**From:** Slaidburn and Easington Parish Council c.o Alison Robinson  
<saepcAR@outlook.com>  
**Sent:** 15 June 2020 19:16  
**To:** Planning  
**Subject:** Planning Application - 3.2020.0328 / 3.2020.0355  
**Categories:** Yellow Category

I write regarding the above planning applications.

house extension + garage:  
 roof - blue slate, grey stone/terrazzo roof glazing + flush F11 velux  
 walls - ex stone, re-pointed, reclaimed stone additions  
 windows - white painted, timber, sash type  
 mv good - open section slim transoms, black, mfr. black PVC

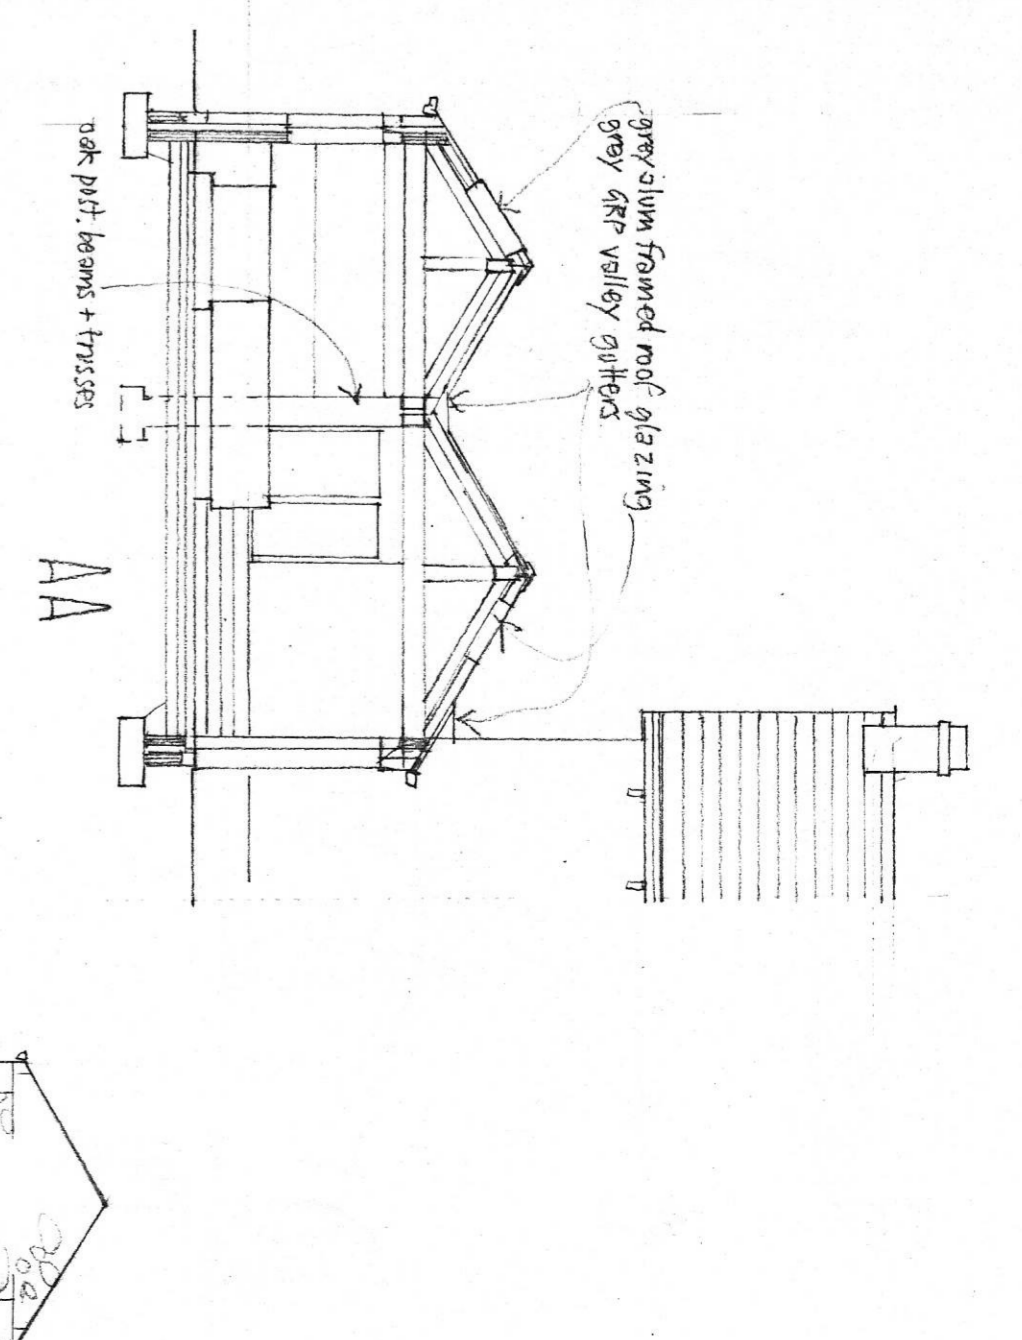
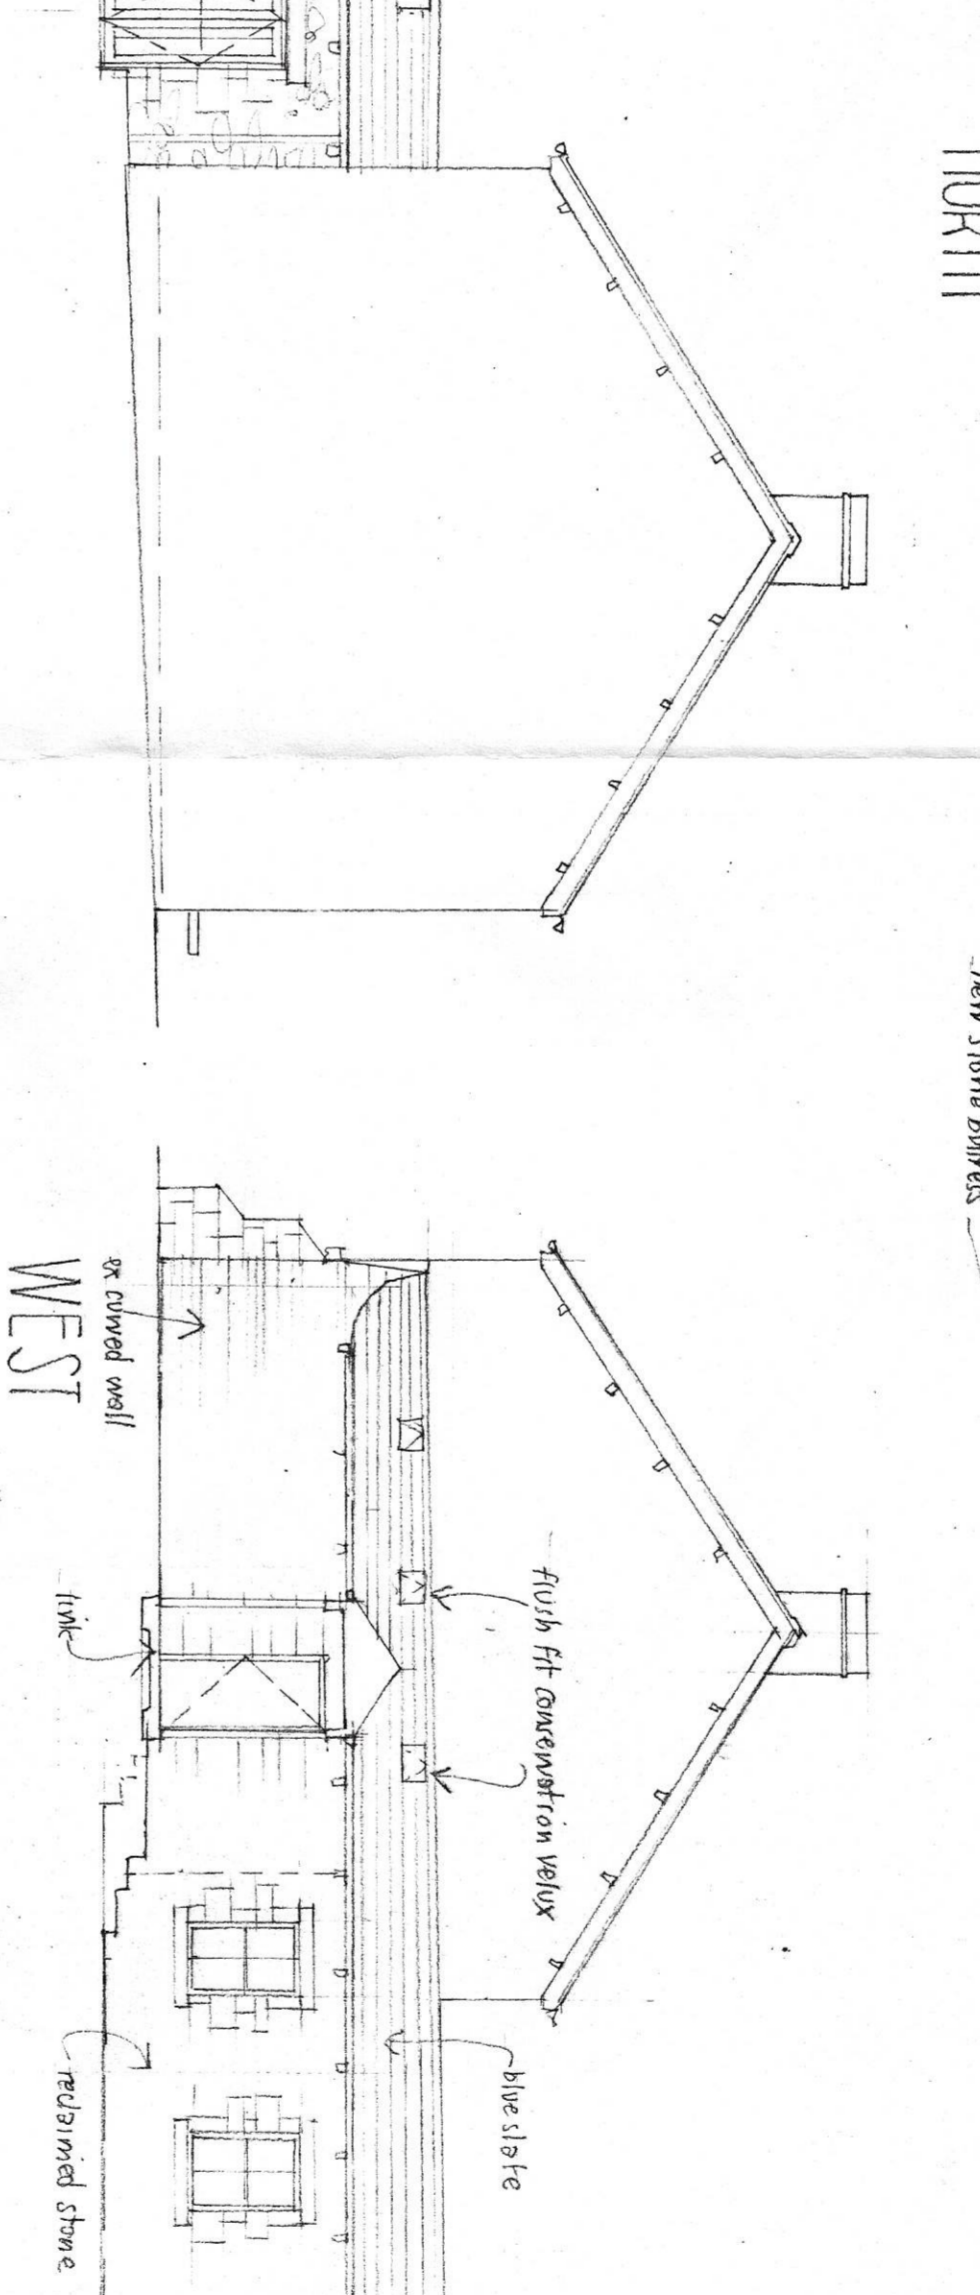
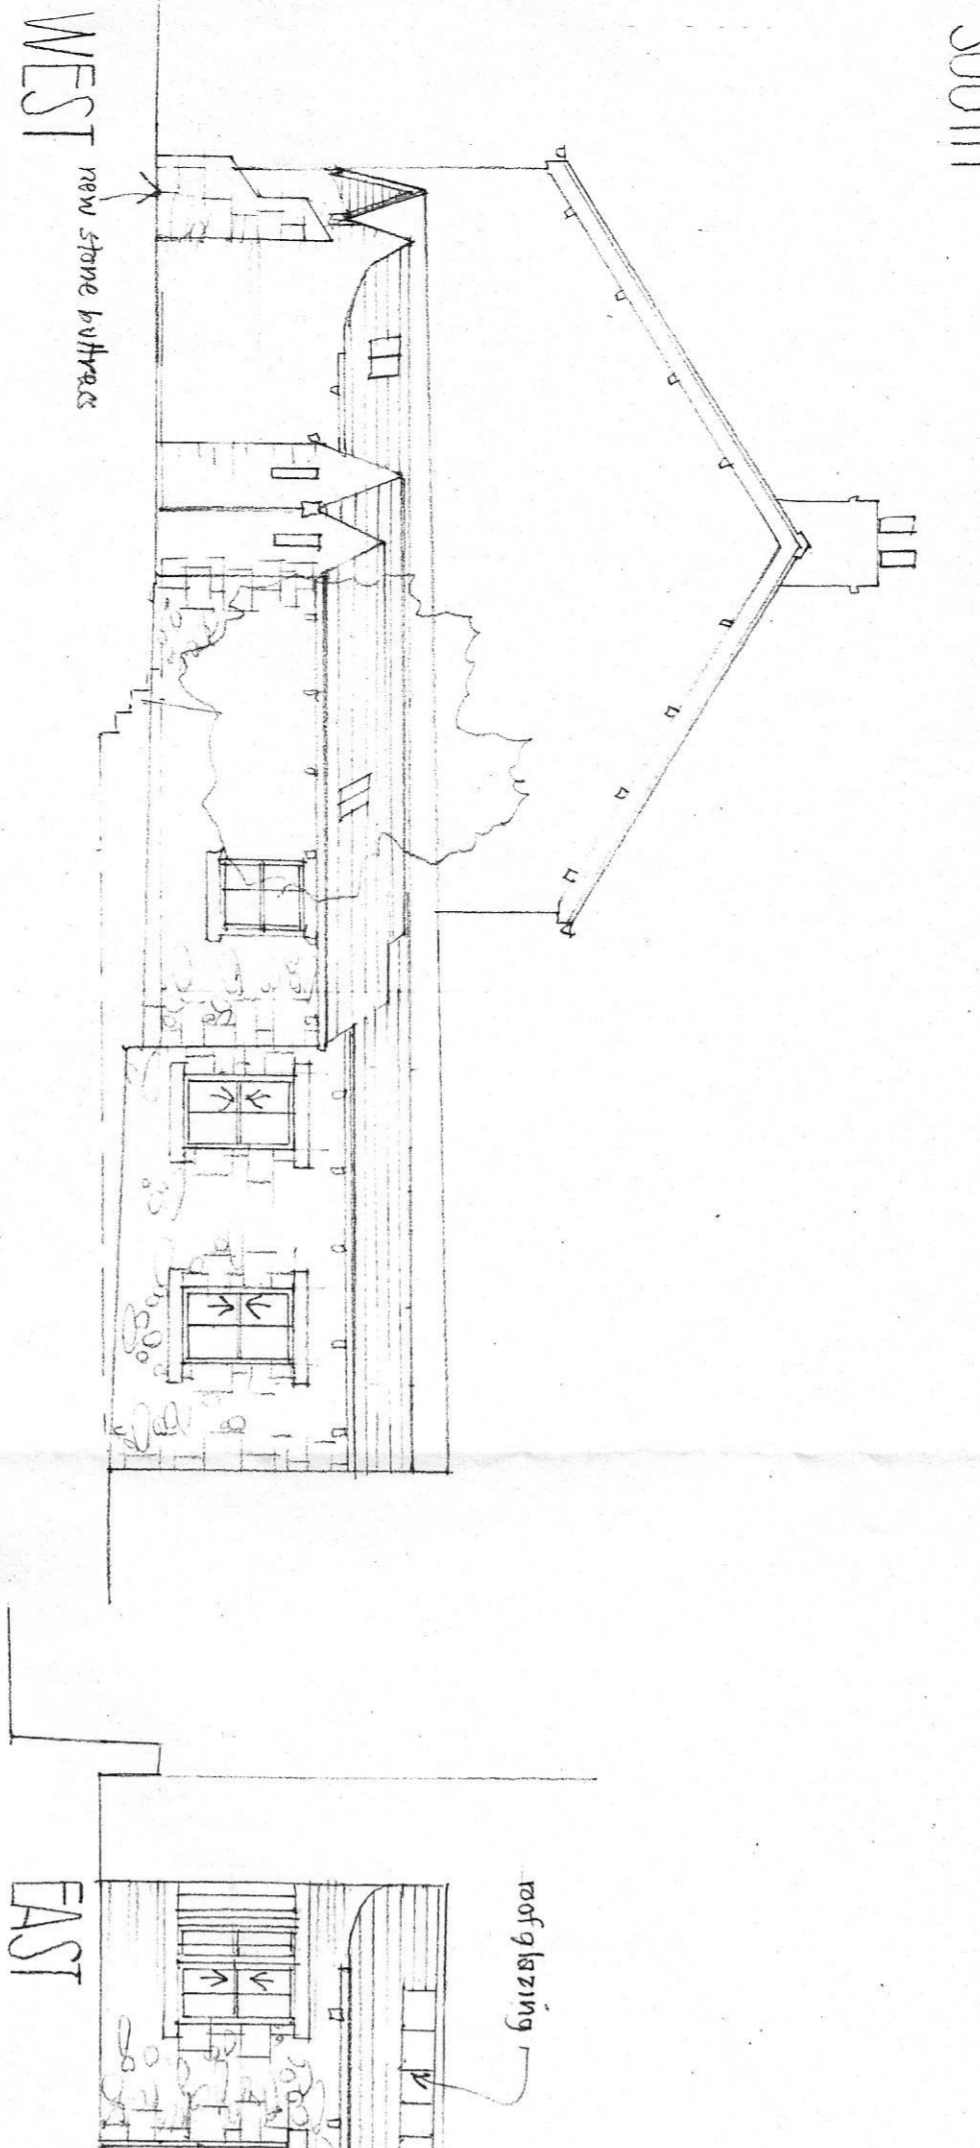
The only comment that the Parish Council wish to make is in relation to the blue slate on the extension. They would recommend that to keep the extension in keeping with the current building stone flag slates are used.
